# Comment for planning application 23/02098/OUT

<b>Application Number</b>	23/02098/OUT
<b>Location</b>	Begbroke Science Park Begbroke Hill Begbroke OX5 1PF
<b>Proposal</b>	<p>Outline application, with all matters reserved, for a multi-phased (severable), comprehensive residential-led mixed use development comprising: Up to 215,000 square metres gross external area of residential floorspace (or c.1,800 homes which depending on the housing mix could result in a higher or lower number of housing units) within Use Class C3/C4 and large houses of multiple occupation (Sui Generis); Supporting social infrastructure including secondary school/primary school(s) (Use Class F1); health, indoor sport and recreation, emergency and nursery facilities (Class E(d)-(f)). Supporting retail, leisure and community uses, including retail (Class E(a)), cafes and restaurants (Class E(b)), commercial and professional services (Class E(c)), a hotel (Use Class C1), local community uses (Class F2), and other local centre uses within a Sui Generis use including public houses, bars and drinking establishments (including with expanded food provision), hot food takeaways, venues for live music performance, thea

Figure 5.1 –Lighting Environmental Classification for the Proposed Development.

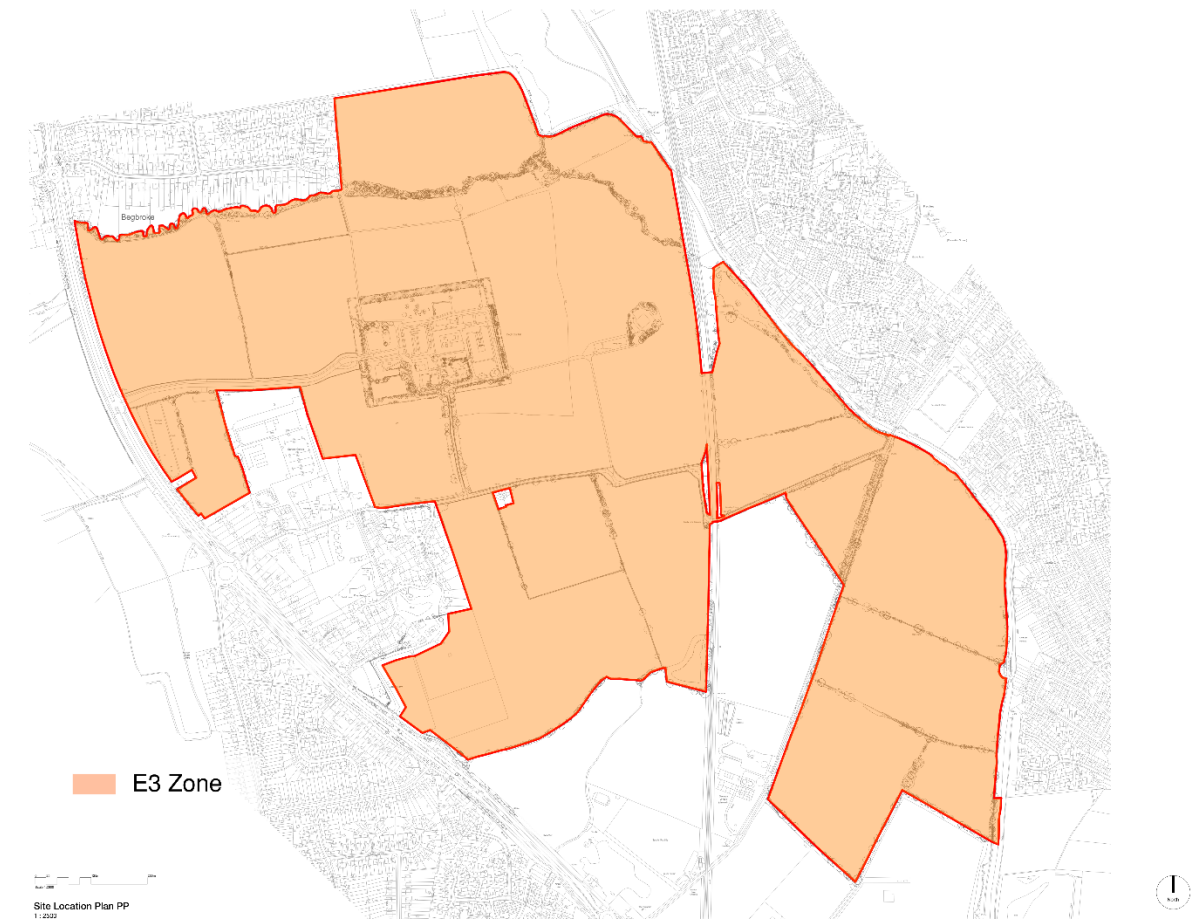
classify this space as Zone E1 ("relatively uninhabited rural areas") in character. It will then be compatible with the actual lighting strategy it is proposing in other sections, and compatible with the Ecology Report and the Oxford Canal Conservation Area. It will maintain an important area of dark skies between Kidlington and the new development. If it is left as Zone E3, future developments on the site could erode this with permissible light spill exceeding what is appropriate.

Figure 6.3. – Illustrative lighting colour temperature strategy

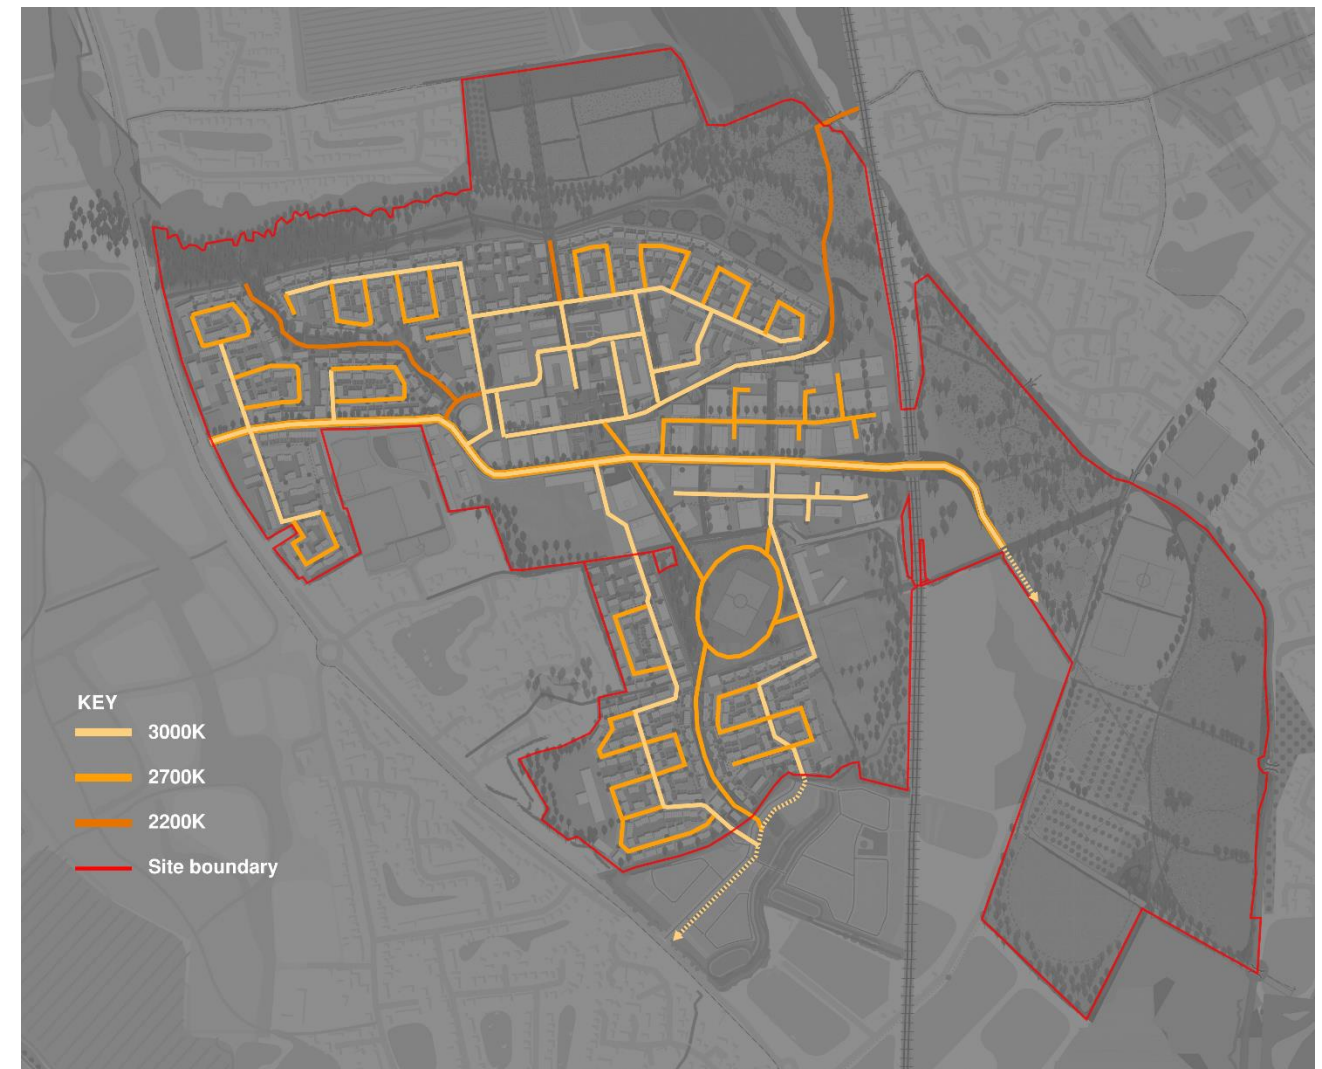
The eastern access route to the east of the railway line in Figure 5.4 is proposed to have neutral white 3000K 4 metre high columns. These are not consistent with best practice for lighting in areas with wildlife and defined bat corridors. Lower level lighting of a warmer colour temperature below 2700K would be preferable.
